# Gate Burton Energy Park

## EN010131

Document Name: Change Request and Consultation Report  
Document Reference: 8.24  
3 October 2023

SHEET TITLE
ACCESS NORTH OFF TORSKEY FERRY ROAD LAYOUT AND SWEEP PATH ANALYSIS

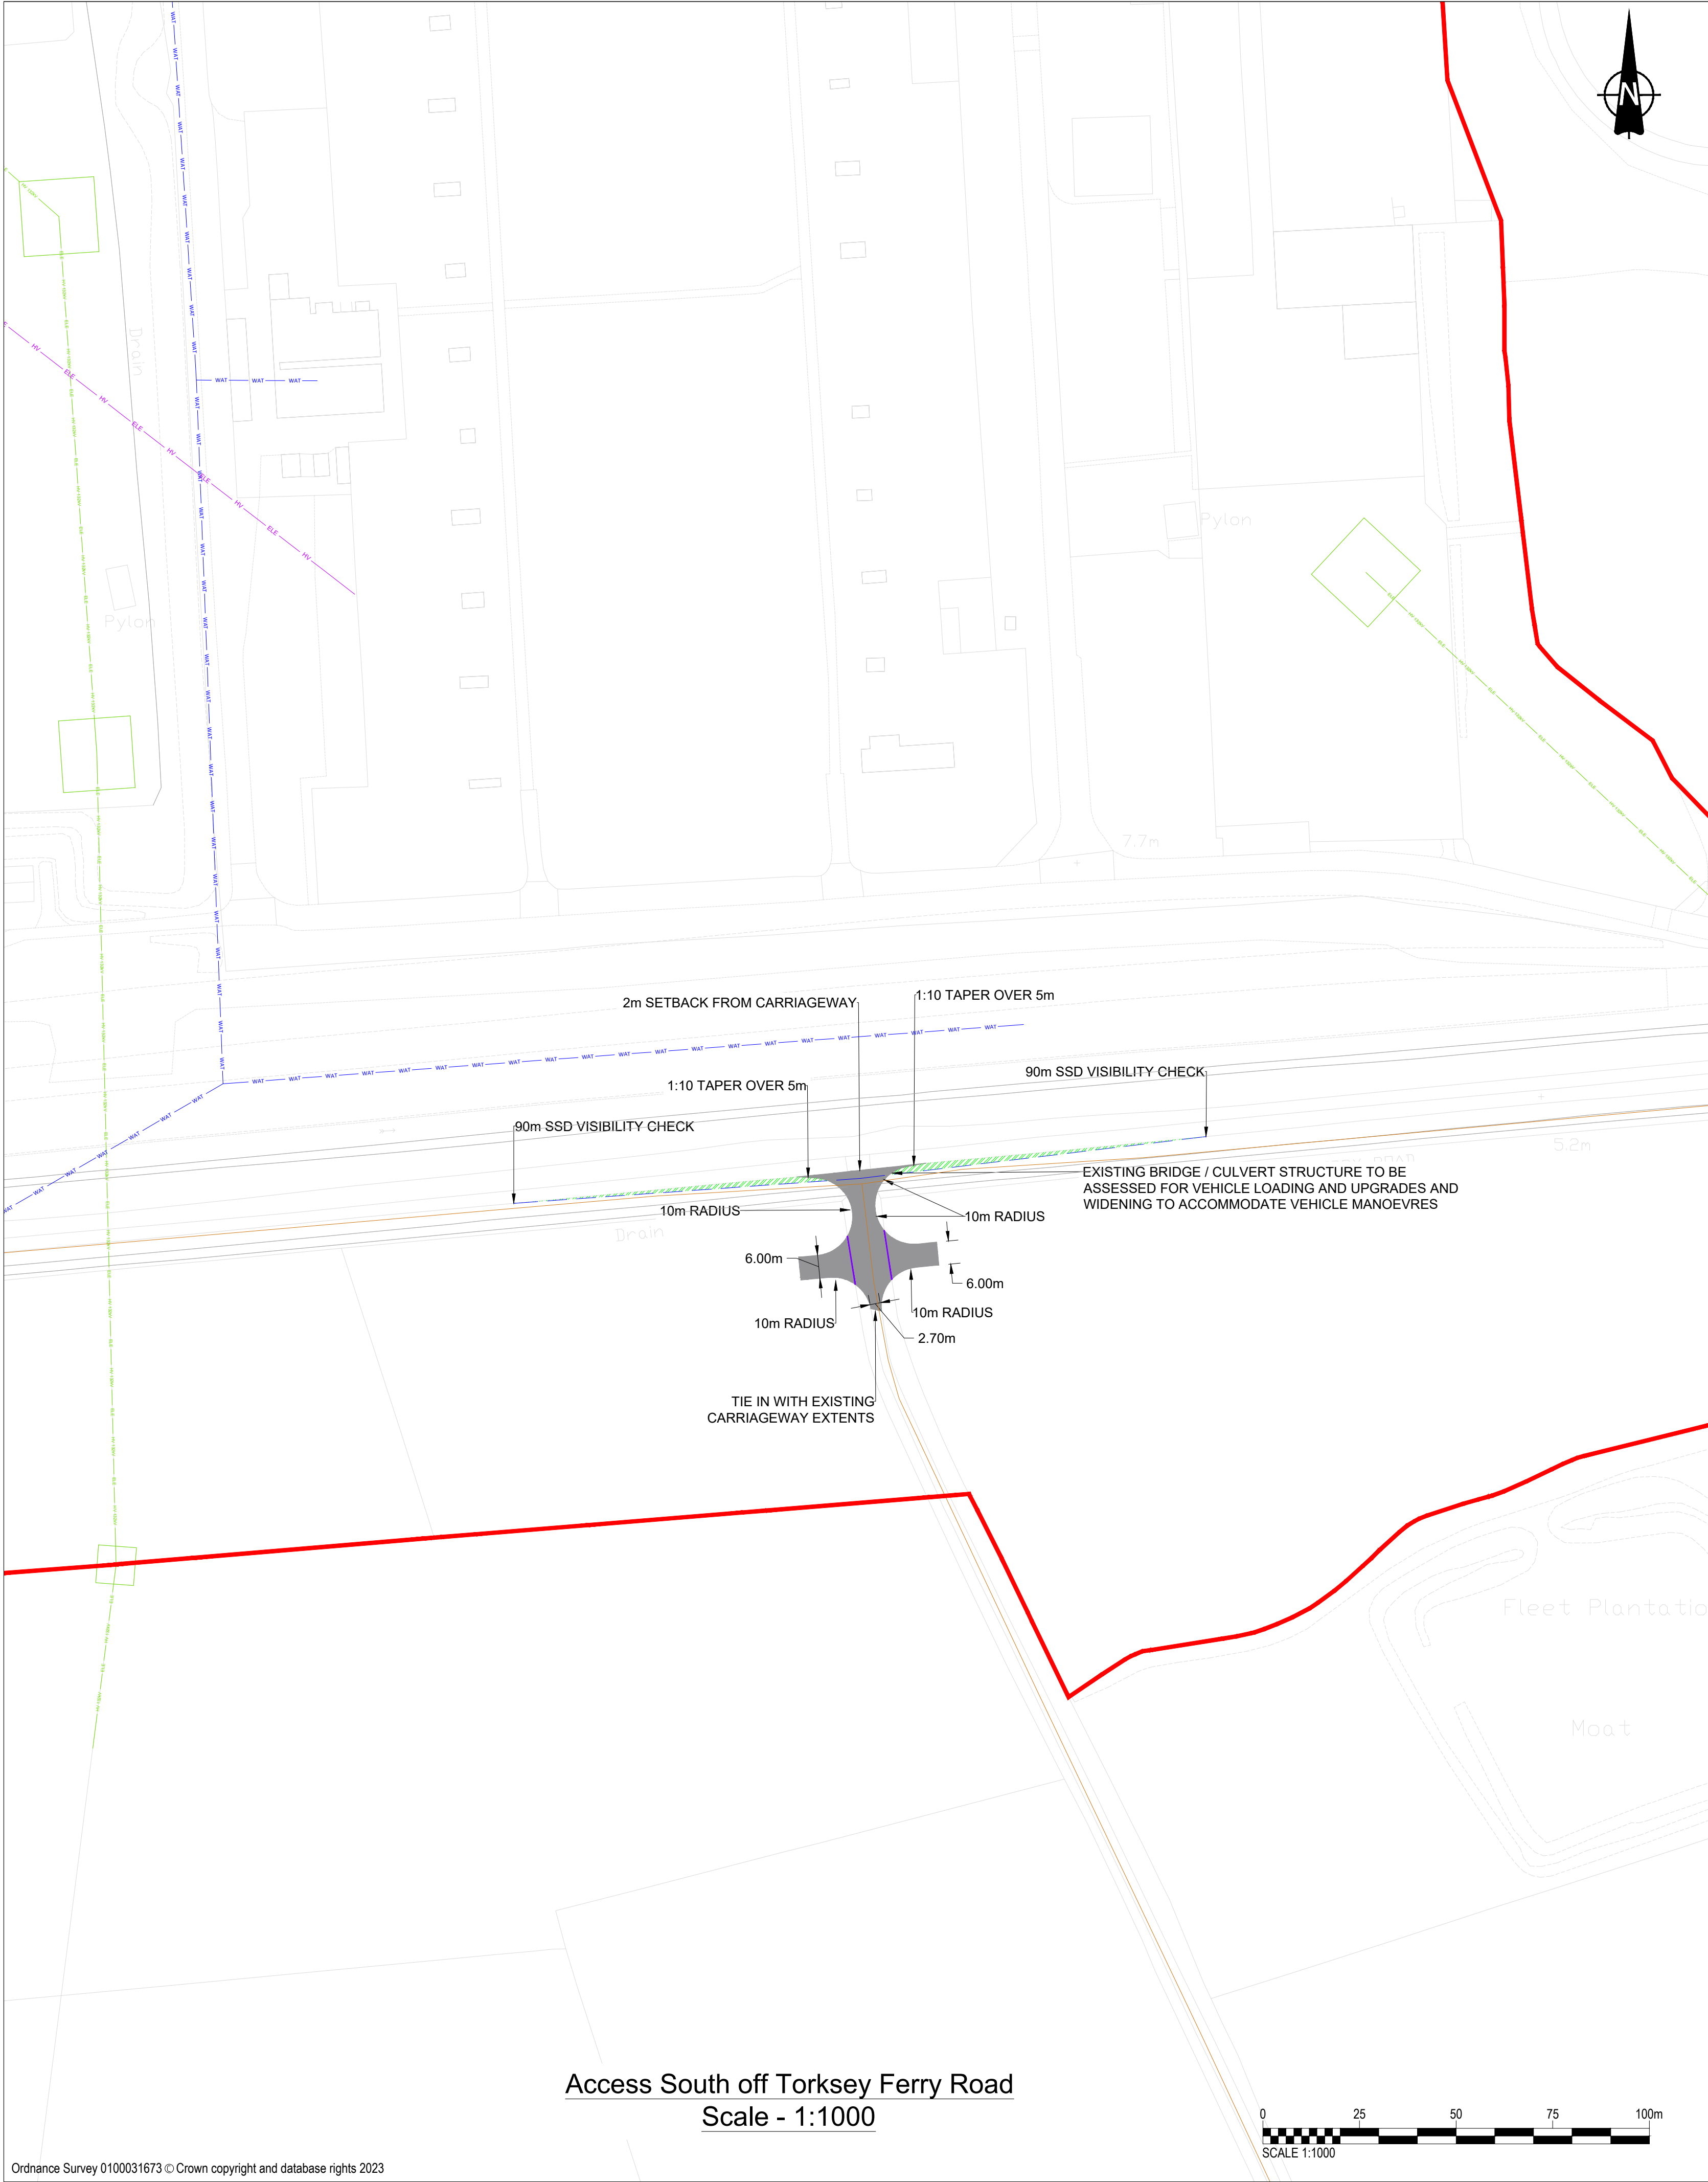
2.3.3 This change also includes an extension to the Order limits immediately to the north of the eastern extension along Torksey Ferry Road (into EDF land) to provide necessary flexibility to accommodate EDF and Uniper's preferences for obtaining access to the Cottam Substation during construction. This land is required due to the gradient, ditch and existing development between Torksey Ferry Road and the Cottam Substation, meaning it is not possible to access the Cottam Substation directly from the south. The route within EDF's land is an existing gravel track.

Access South off Torksey Ferry Road
Scale - 1:1000

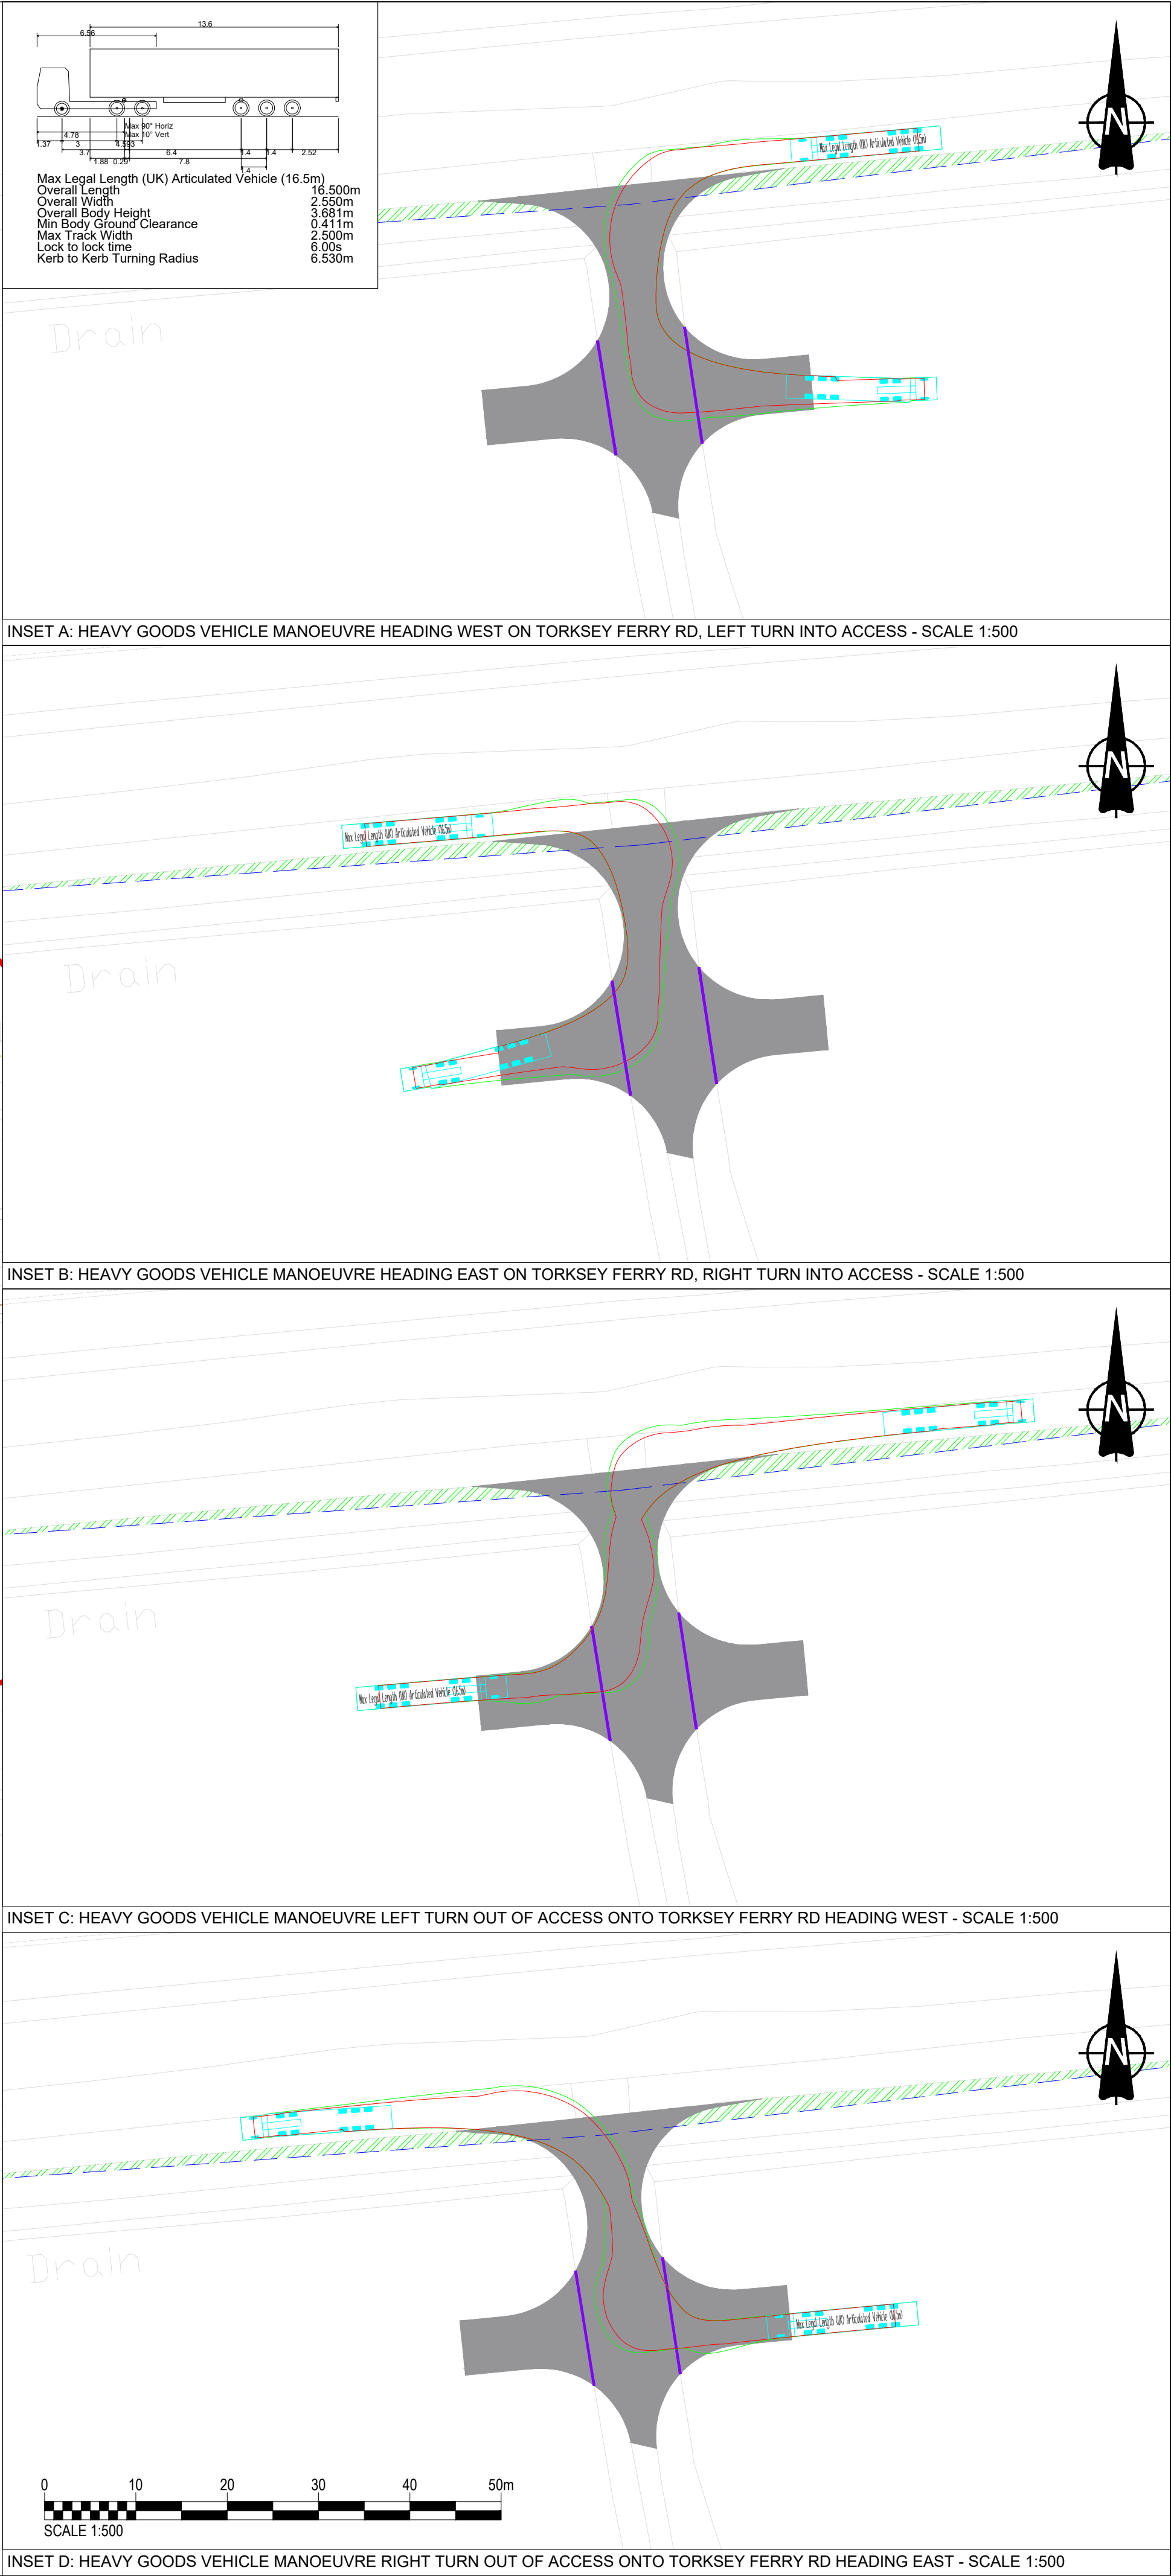
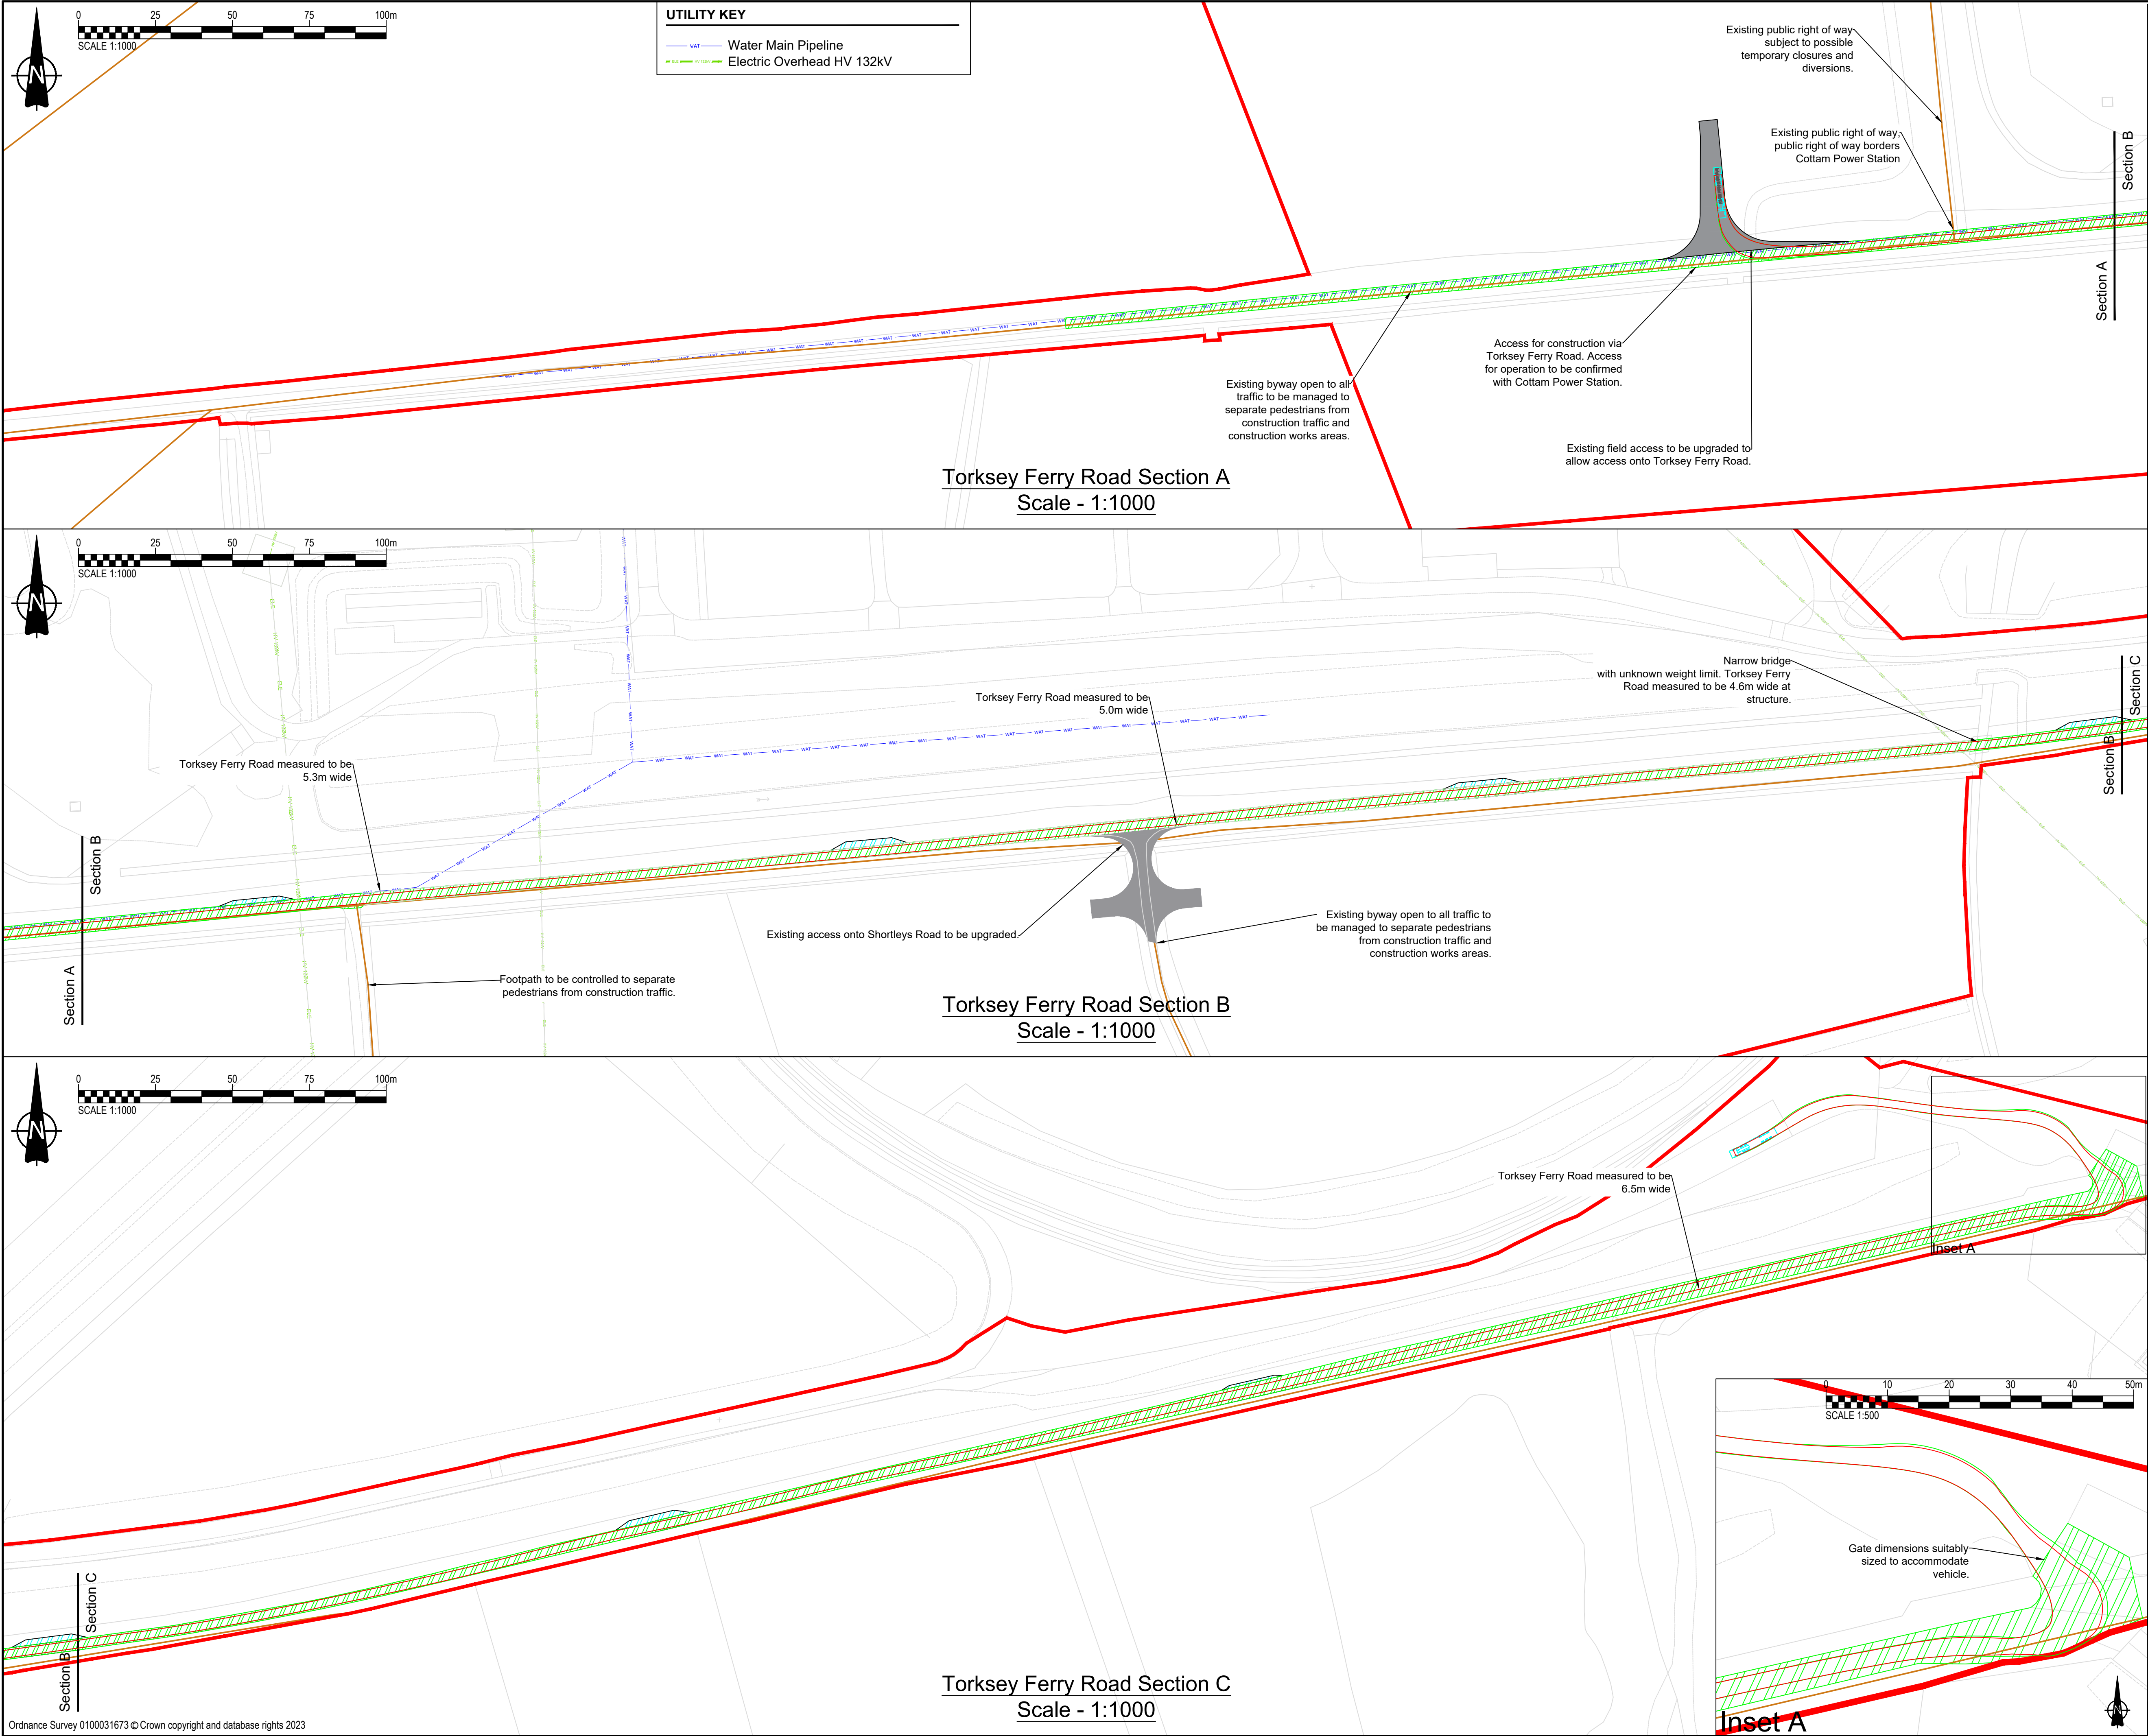
- 2.2.1 Change 1 comprises an extension to the Order limits immediately to the south of Torksey Ferry Road, for works to construct and operate the 400kV cable and associated development. The reason for this change is to allow further space for the Scheme's cables to turn and enter the Cottam Substation from the south. The cables will be located underground.

- the radii (or turning circle) required for the cables to turn first to head east in parallel to Torksey Ferry Road and then to turn north to enter the Cottam Substation;
- the separation distances required between the cables; and
- the need to minimise interactions with existing site constraints such as overhead lines, ditches and a bund.
